MMO Reference: DCO/2016/00003  
Planning Inspectorate Reference:  
EN010084  
Identification Number: 20012636

## **Planning Act 2008, Vattenfall Wind Power Limited, Proposed Thanet Extension Offshore Wind Farm**

This document forms the MMO's deadline 5 submission, comprising:

Figure 14.1
Thanet Extension Offshore Wind Farm Proposed Development Boundary.

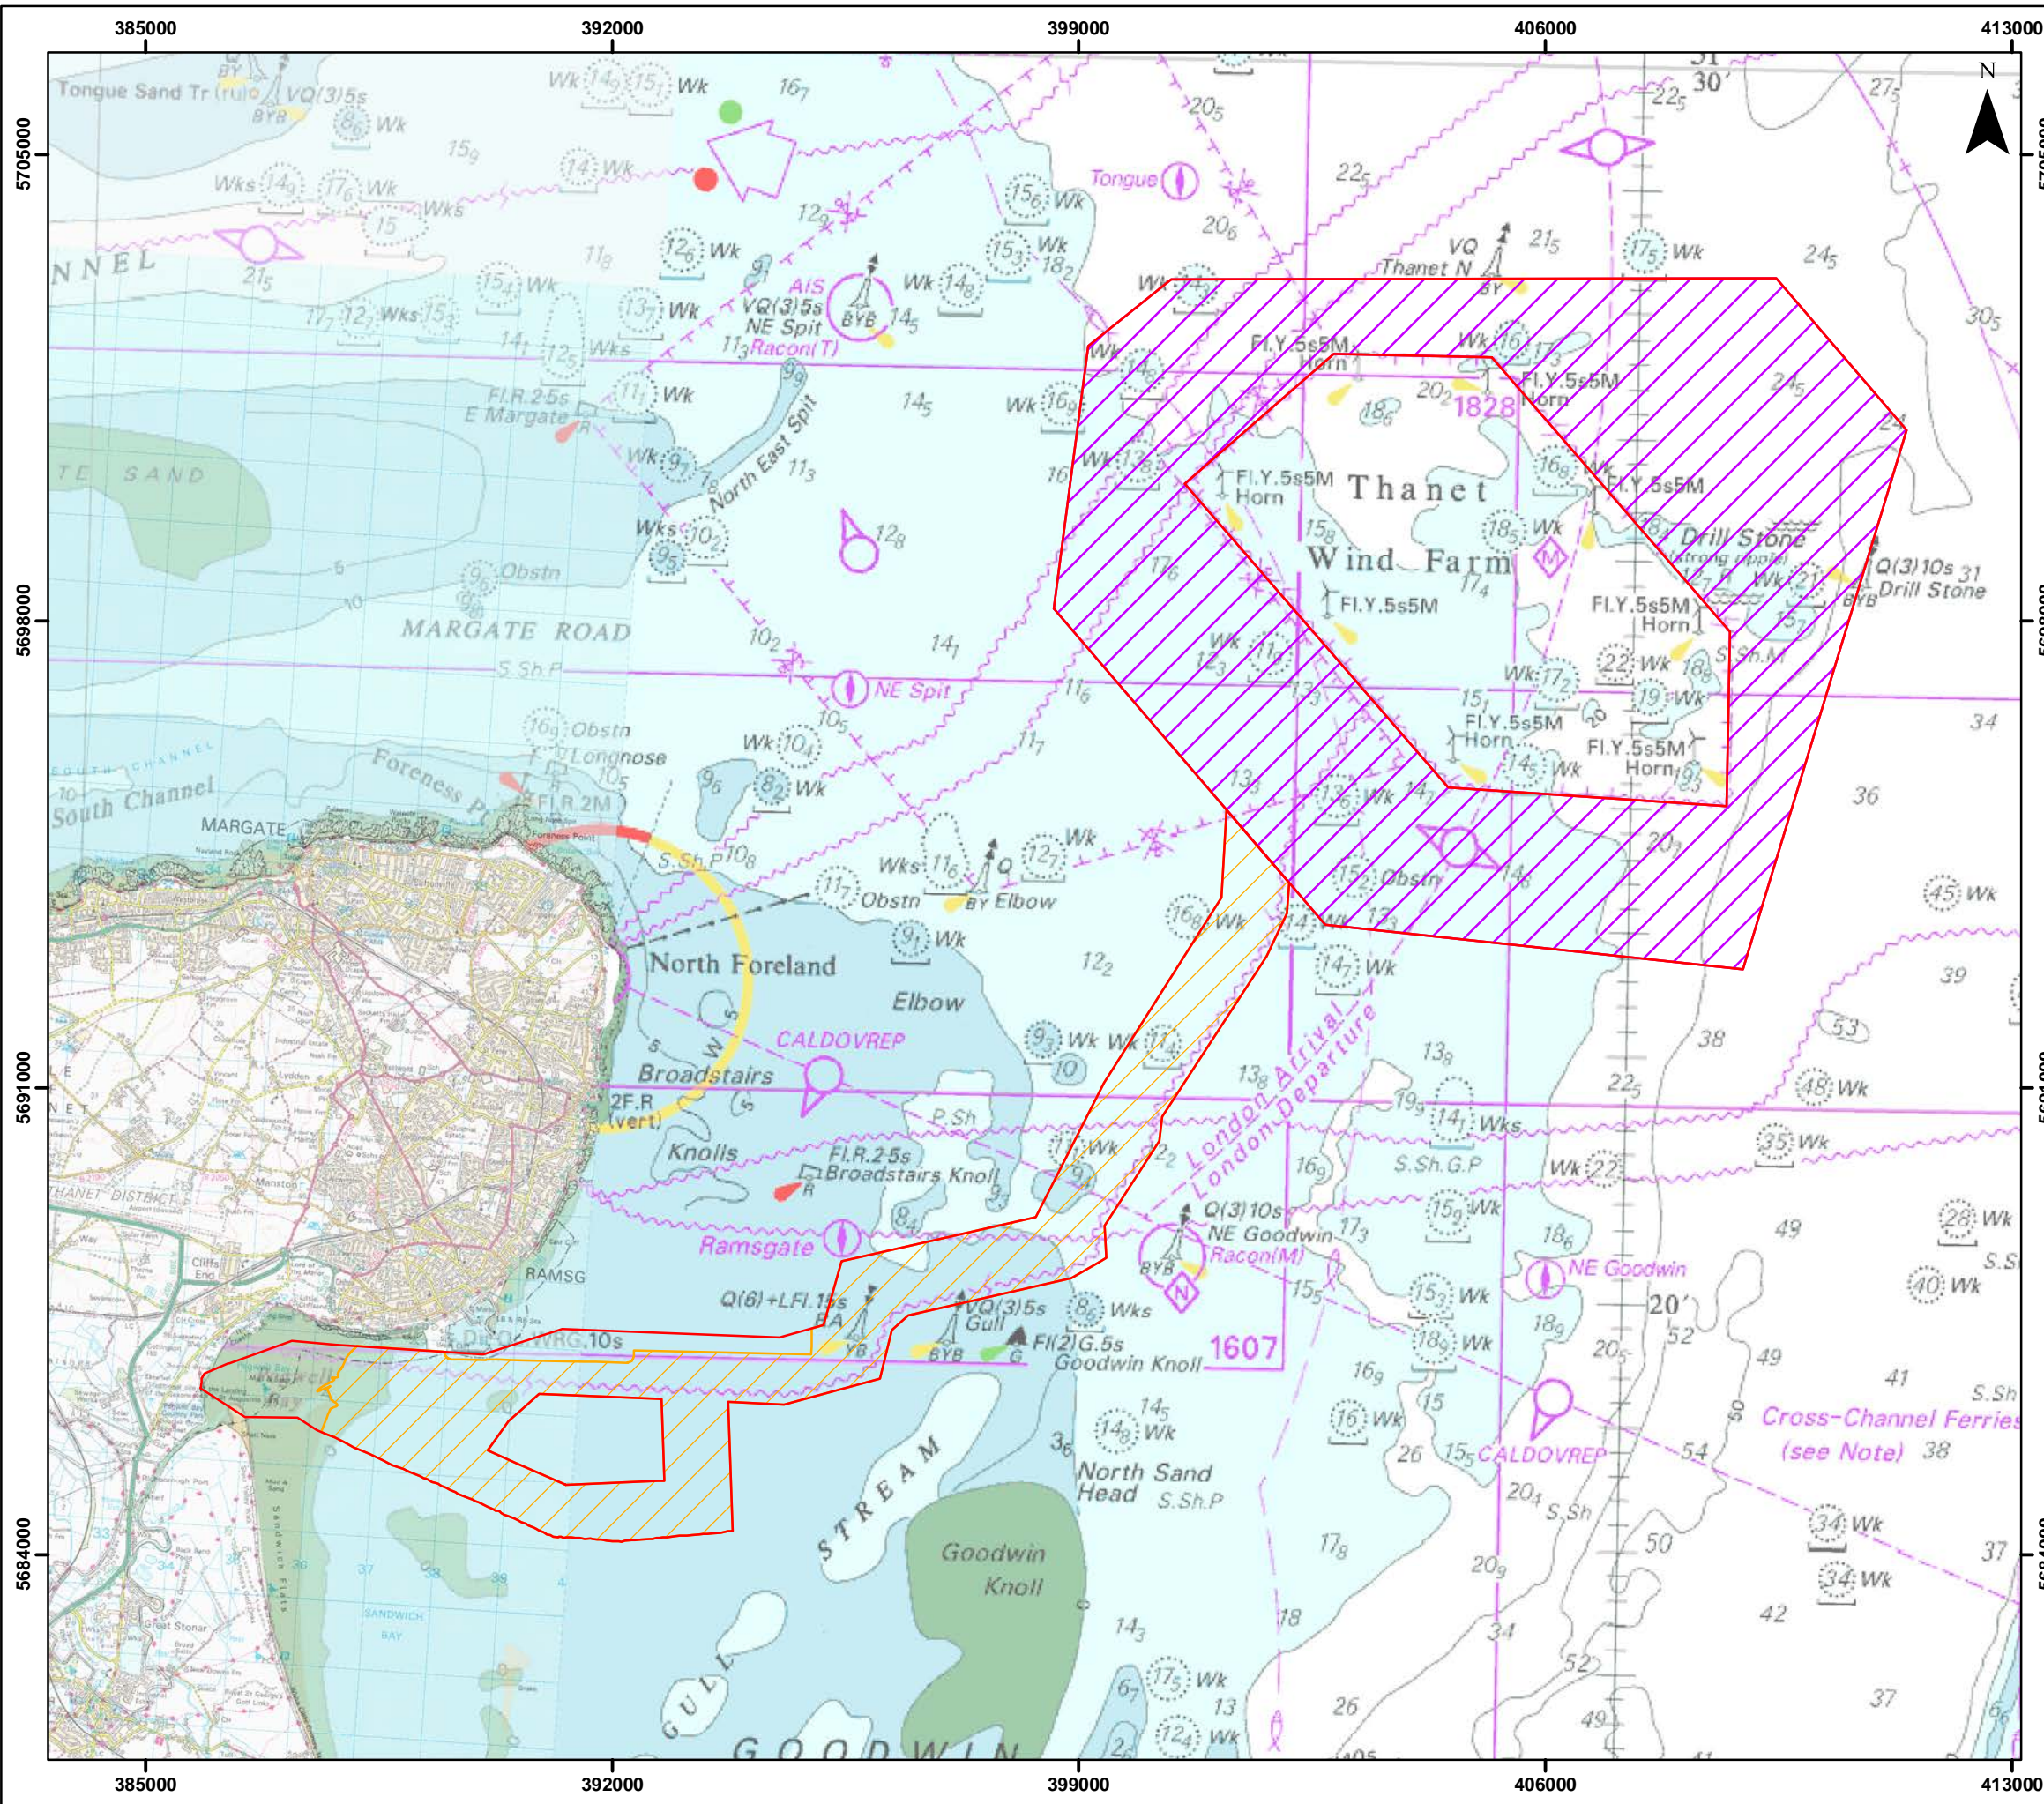
**3.1.14** The MMO requests that the maximum disposal volumes for each activity are clearly defined on the DML for each disposal site, and the disposal sites are accurately referenced on the DMLs. The MMO has recently provided the disposal site references to the applicant and will therefore look for these changes in the next revision of the dDCO.

**3.1.15** The maximum disposal volumes stated in part 3, condition 1(d), have combined the disposal volumes from drill arisings and the disposal volumes for seabed preparation. These should be separated out by activity. Disposal from drill arisings is of different material to sandwave levelling, and the current wording could allow for the disposal of more drill arisings than has been assessed in the ES. Furthermore, the total figure stated in the condition does not total the two figures cited in (i) and (ii).
